**RE: Coors Pavilion Subdivision
9154 Coors Blvd
Grading Plan
Engineer's Stamp Date: 1/31/2017
Hydrology File: G11D069**

Based upon the information provided in your submittal received 2/1/17, the Grading Plan is not approved for Grading Permit. The following comments need to be addressed for approval of the above referenced project:

### HYDROLOGY

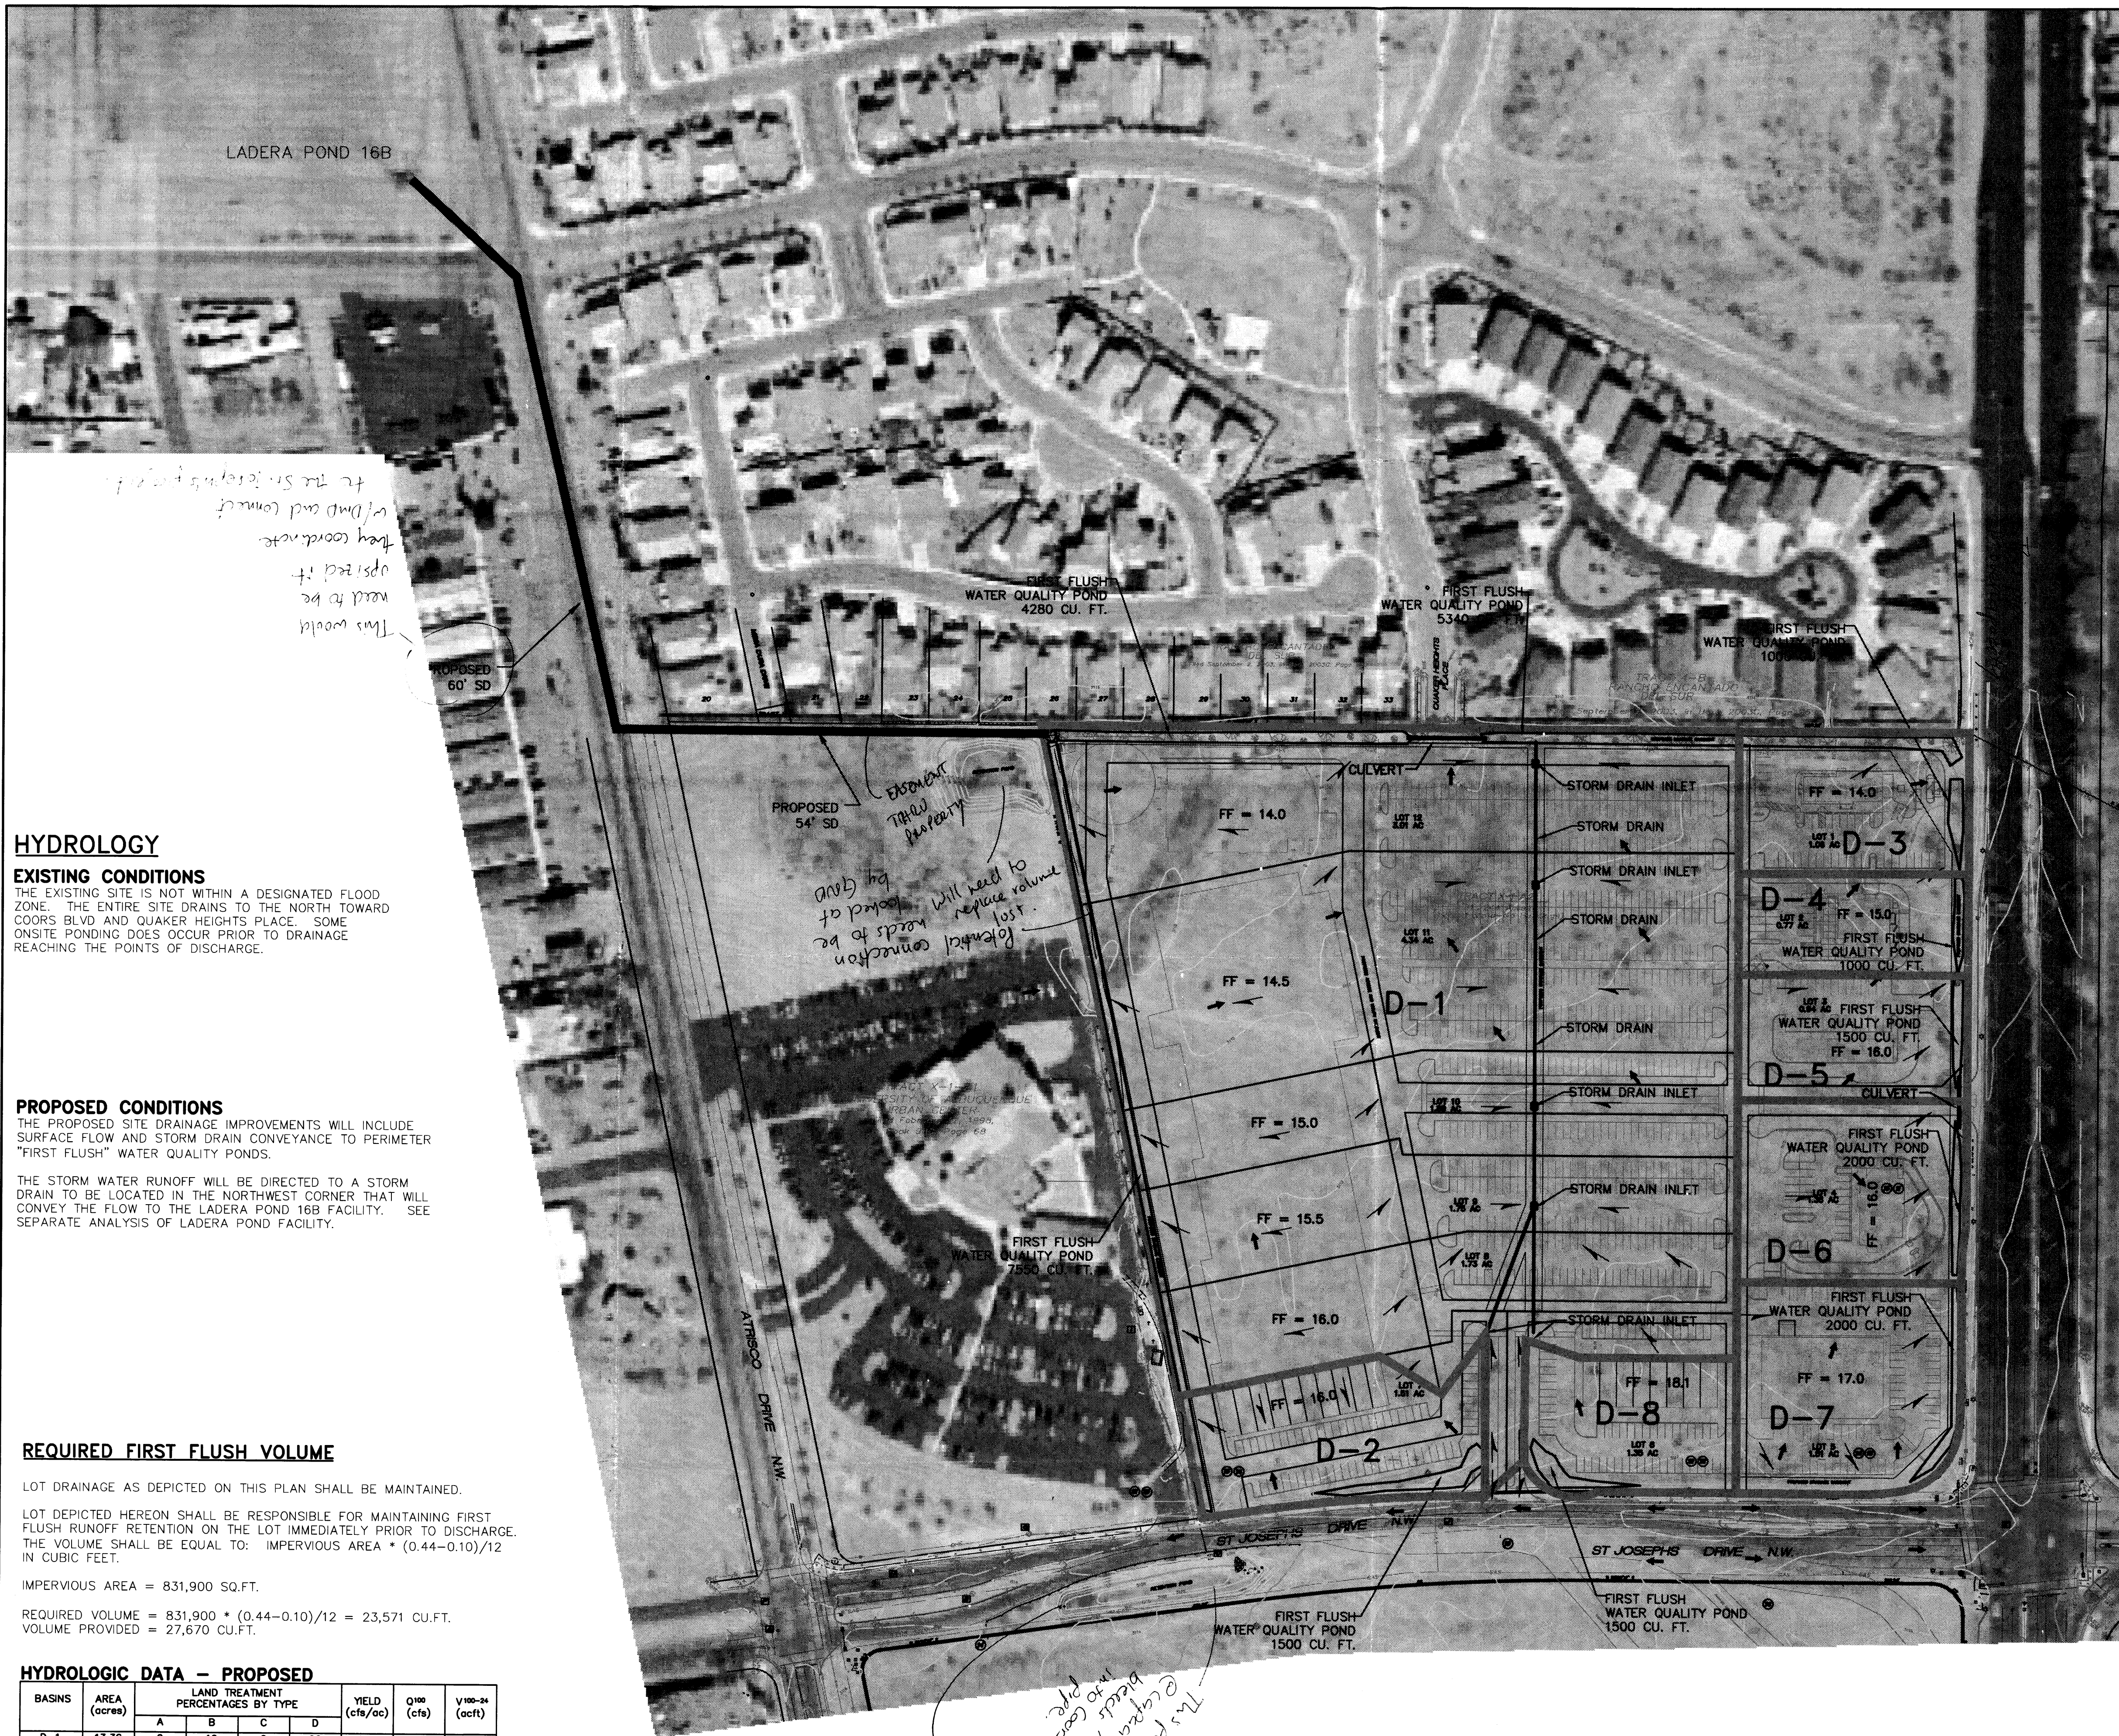
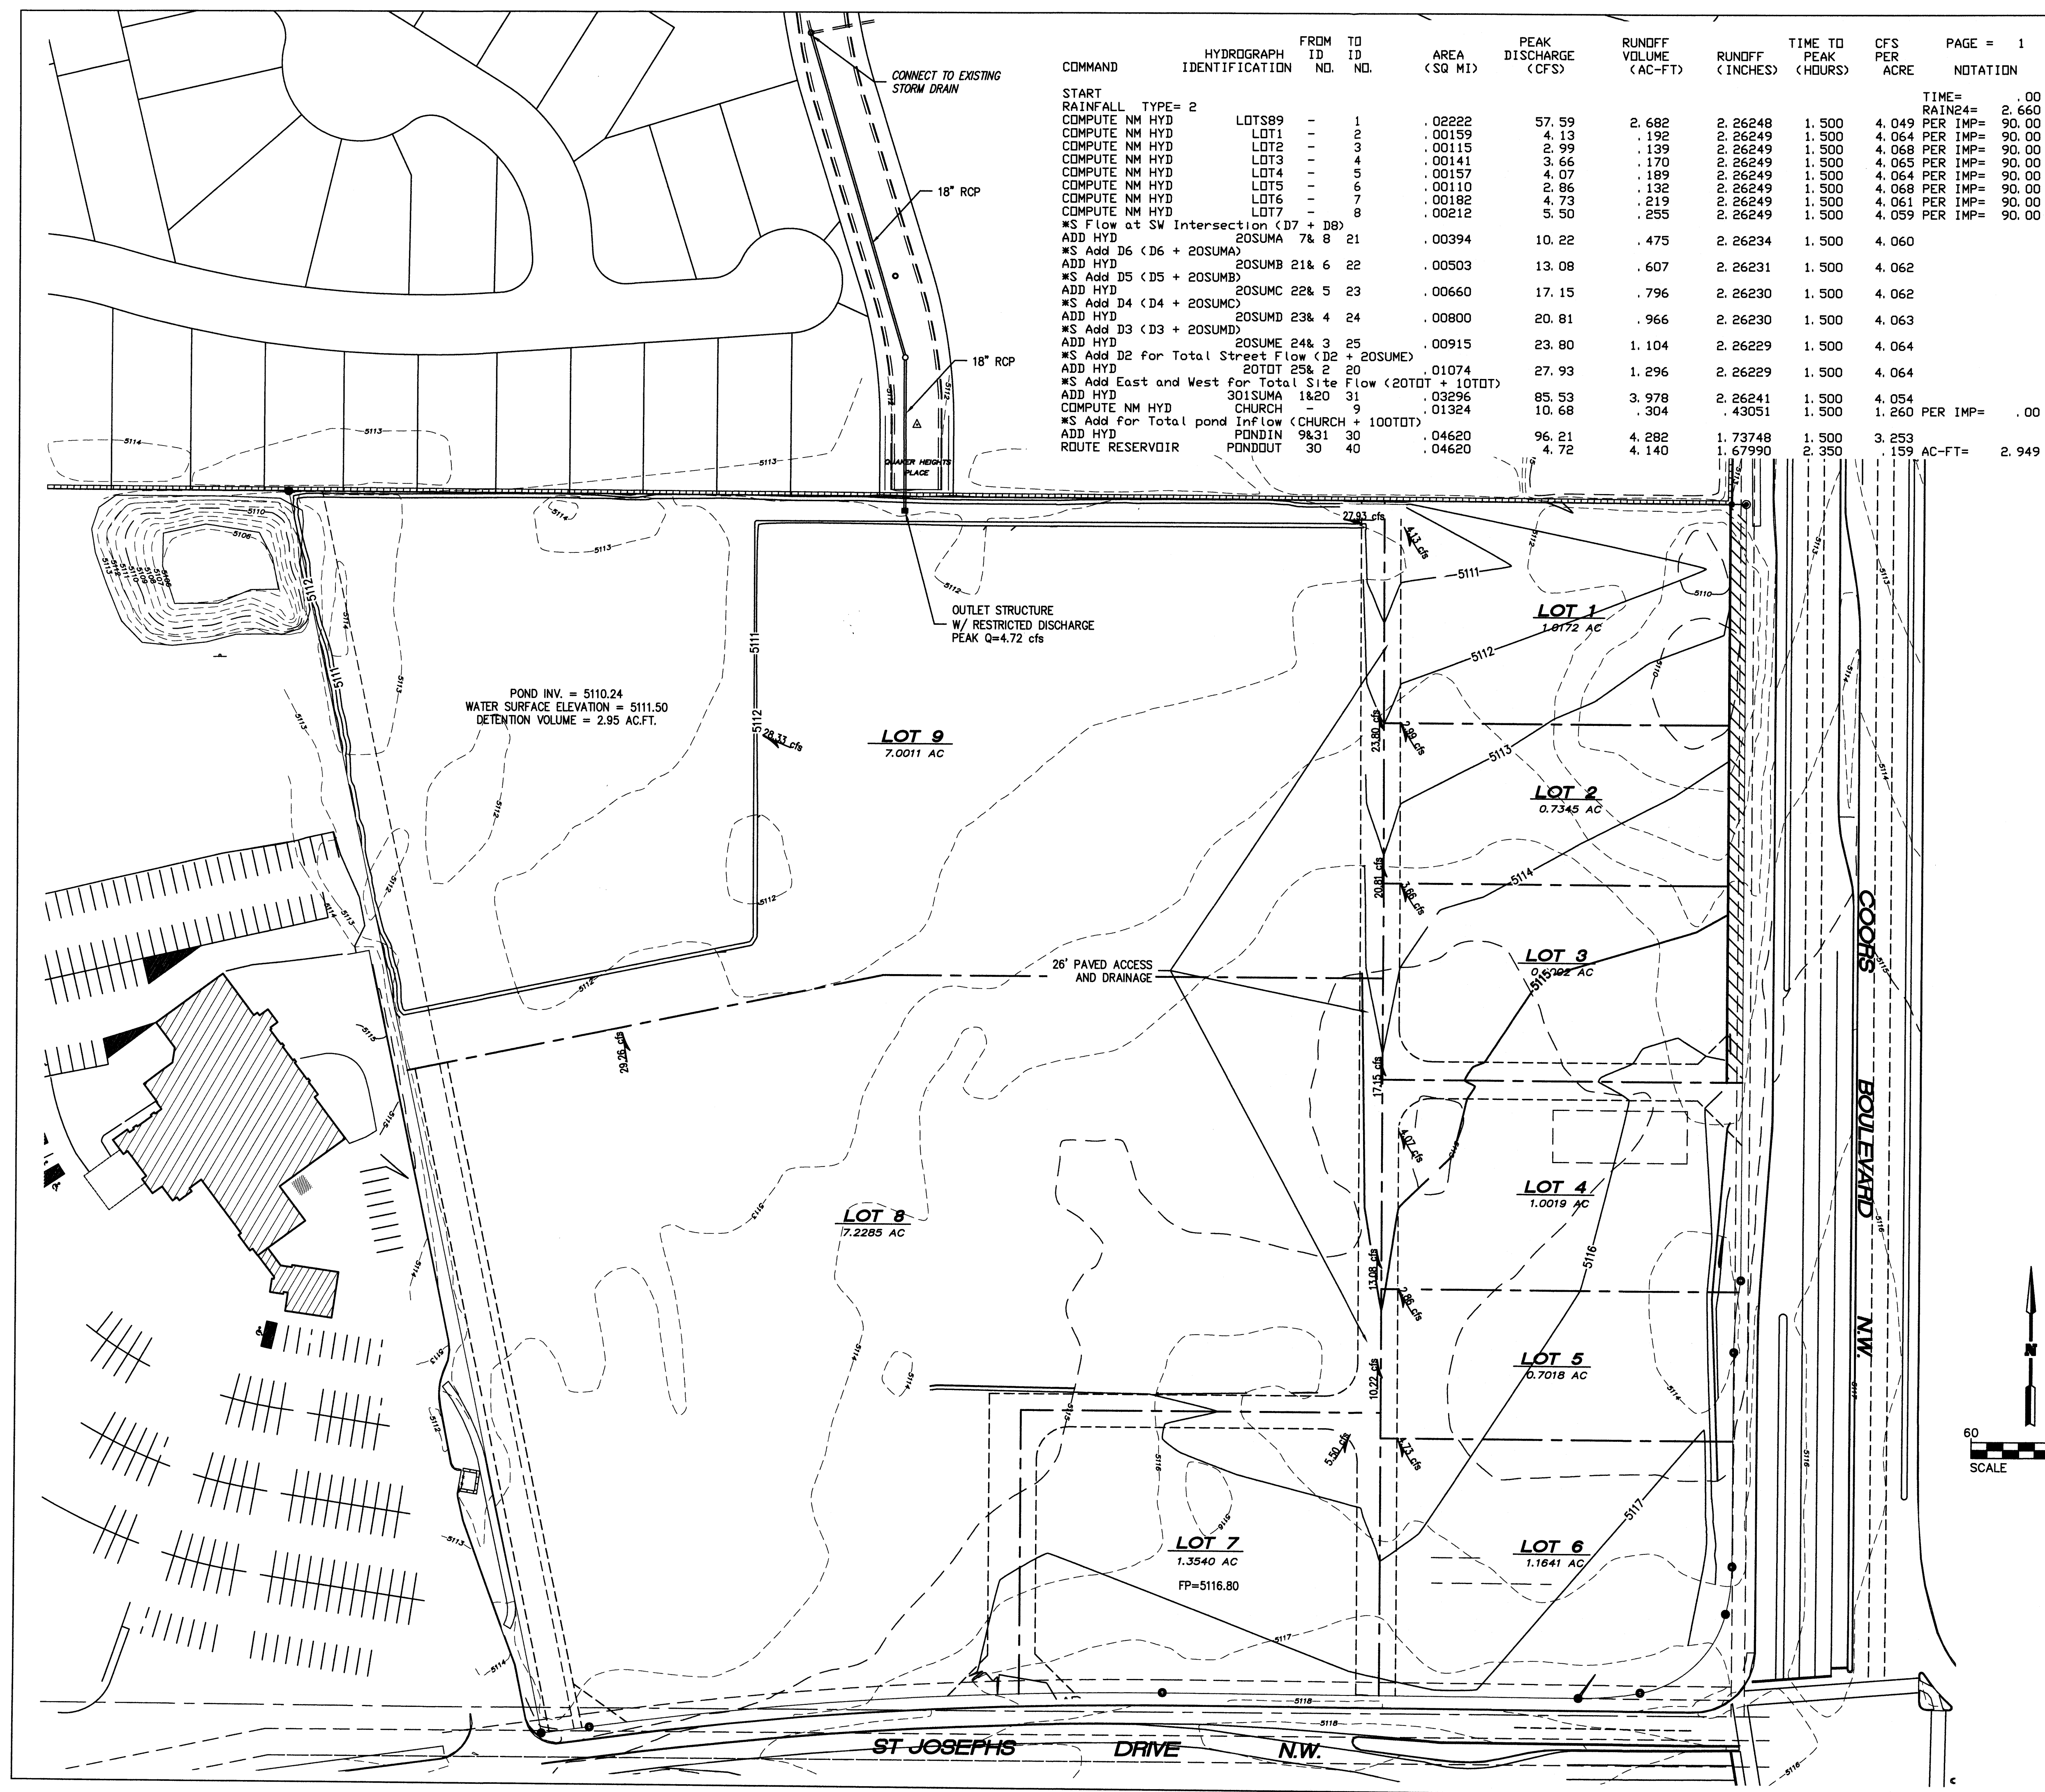
- a. The area for the church basin appears too low and is not consistent with the AHYMO model.
- b. Land treatments should be consistent with the AHYMO model.

- a. Specify RCP Class IV for the storm drain passing under the garden wall, assuming the garden wall will remain over the pipe.
- b. Add a manhole and a polyline with annotation at the public/private interface of the storm drain.
- c. Provide storm drain invert elevation and grate elevations for the outlet structure.
- d. Detaining the first flush volume in a 3 inch deep by 2.6 acre uniformly flat earth surface pond is not feasible from a construction standpoint. Excavate an additional 0.2 feet to provide for the allowable error in construction finished grades.
- e. A local depression, 2 feet beneath the PVC pipe inverts, needs to be provided for erosion and sediment control. This depression must be maintainable with 3:1 or flatter slopes and at least 4 feet of flat bottom around the outlet structure to prevent the storm drain from silting in.

- a. No ponding will be allowed over the 20 foot ABCWUA easement. The pond boundary will need to be adjusted to avoid this.
- b. The maximum water surface elevation of the pond (5011.50 ft) will need to be restricted to the private access and cannot encroach into lots 1 and 2 beyond the drainage easement boundary.
- c. Provide additional elevation data along the private access and lots 1 and 2 showing that ponding will be restricted to the private access easement and pond.

- a. The AHYMO model determined a contribution of 10.68 cfs from the church and the drawing shows a contribution of 29.26 cfs.
- b. Reorient the flow arrows to make it clear that each lot (for lots 1-7) will discharge directly to the private access as modeled and not across adjacent lots.
- c. Lot 2 shows a peak discharge of 6.65 cfs, not 2.99 cfs as shown in the model.
- d. Lot 4 shows a peak discharge of 6.93 cfs, not 4.07 cfs as shown in the model.
- e. Line types are difficult to discern and ambiguous, especially along Coors. Screen-back (gray) existing contours and existing features, change line types to improve clarity, update the legend, and label all easements and ROWs.
- f. Add spot elevations though the deceleration lane along Coors for top of curb and flow line.
- g. Add to the narrative clarification that this master drainage plan is only for grading of the road and pond.
